# PORTLAND MAINE

April 1, 2008

RE: 95 Canco Road – 141 F019 – R-3 – unpermitted addition – permit #08-0242

This part added w/out perm. Not part of permitted footprint

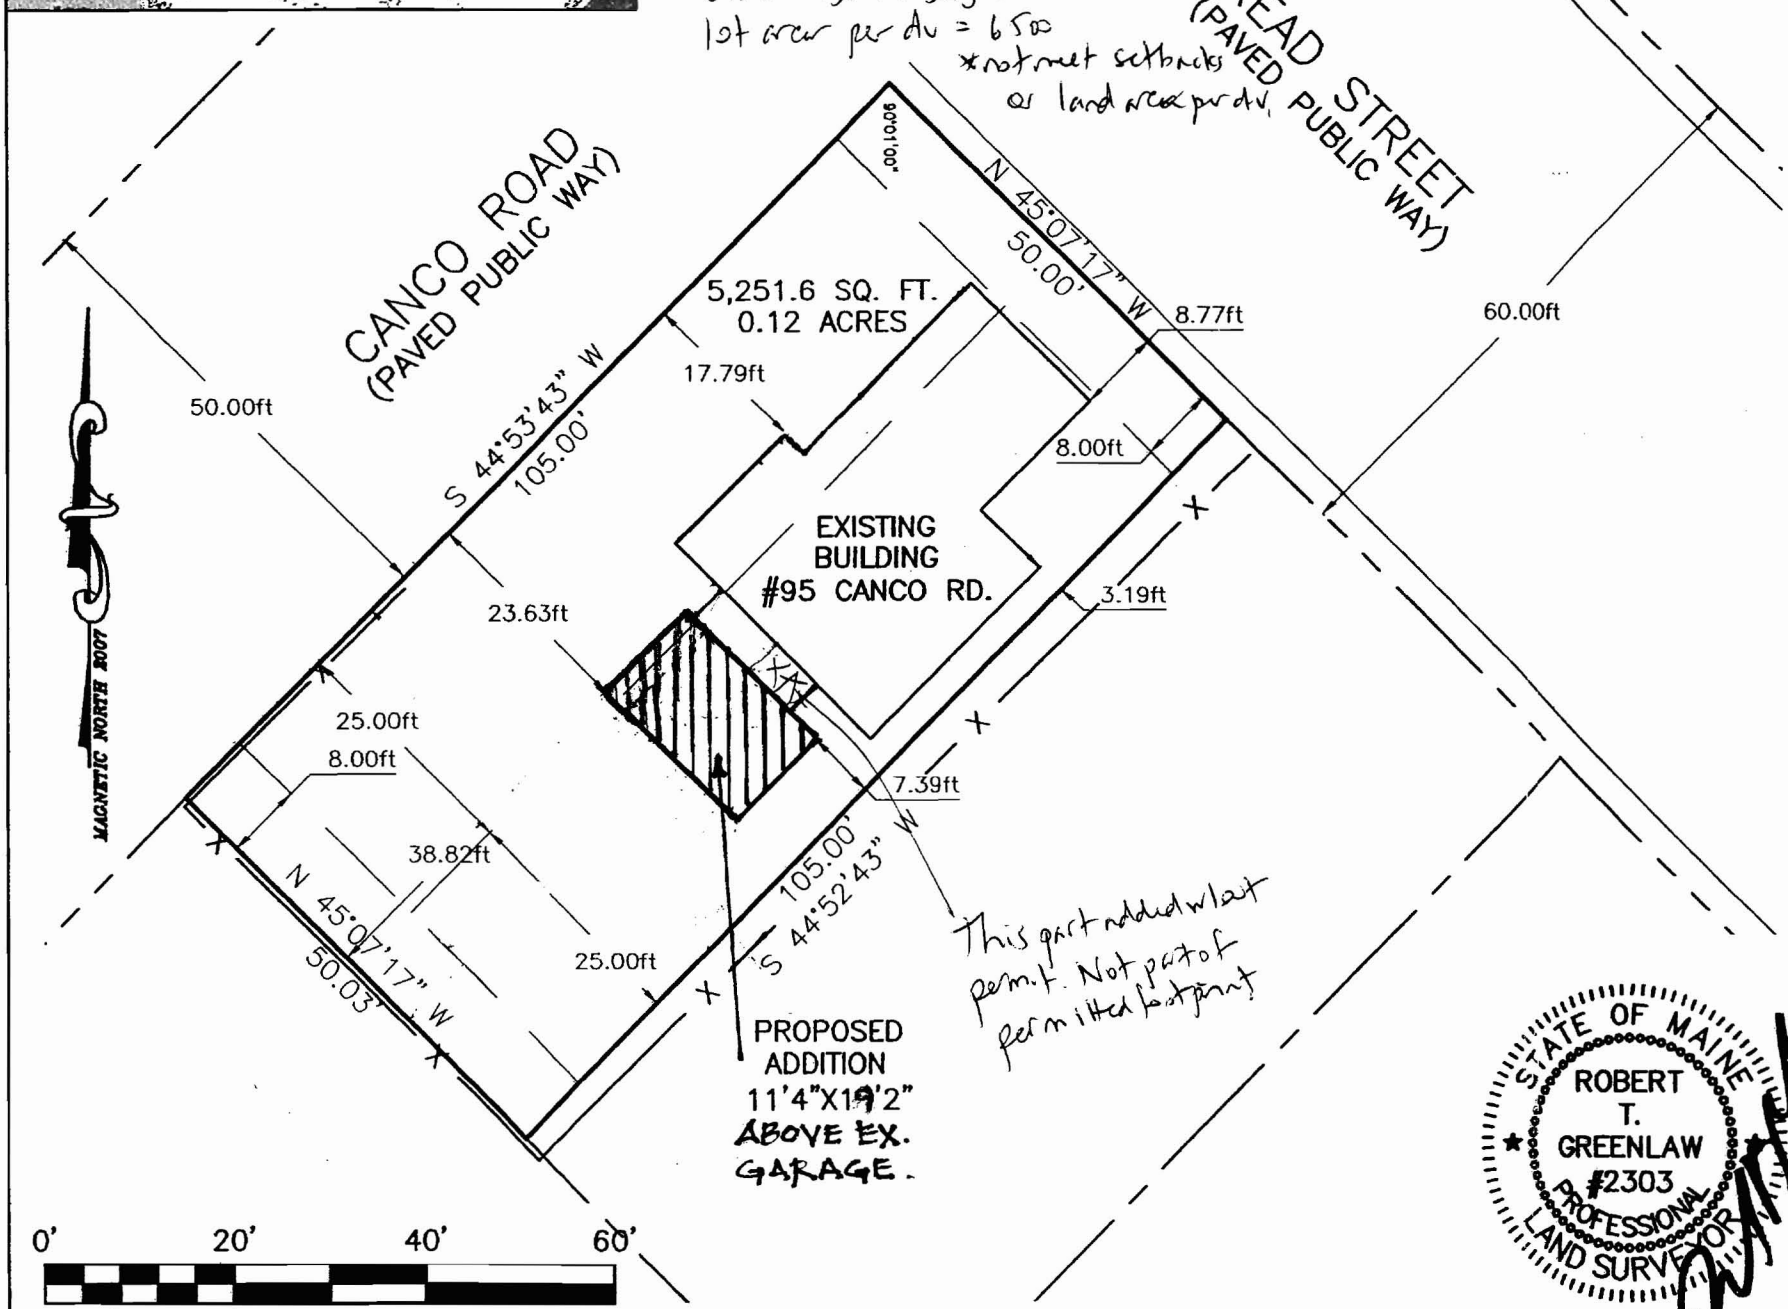
In reviewing your application to raise the roof of your garage, it came to my attention that part of your existing house was built without a permit. In looking at our records, when the house was built in 1941, the area that connected the garage to the house was five feet wide by eight and a half feet deep. At some point the depth of that area was expanded by six feet to add thirty square feet of structure to the rear of this connector. There is no record of a permit for that thirty square foot addition. Since it was added without a permit, it is not legal, and it must be legalized or removed.

Section 14-90(d)(2) of the ordinance states that the required rear setback for the R-3 residential zone is twenty-five feet. The site plan submitted with the permit shows that the rear setback to the thirty-foot addition is eleven feet. Since the addition does not meet the required rear setback, this office cannot approve a permit “after the fact”.

The ordinance under Section 14-90(b), states that the minimum lot area required per dwelling unit is 6,500 square feet. The square footage of the lot for 95 Canco Road is 5251.6 square feet according to the site plan. Therefore, the lot is legally nonconforming. The ordinance, under section 14-388, states that a building that is nonconforming as to area per dwelling unit cannot be enlarged unless the building can be made to conform to the land area per dwelling unit requirement. Since the lot is legally nonconforming as to land area per dwelling unit, you cannot enlarge the existing building, so once again this office cannot approve a permit “after the fact”.

fill out the variance appeal application. If you choose not to file the appeals, then you will have to remove the thirty-foot addition to bring the house into compliance.
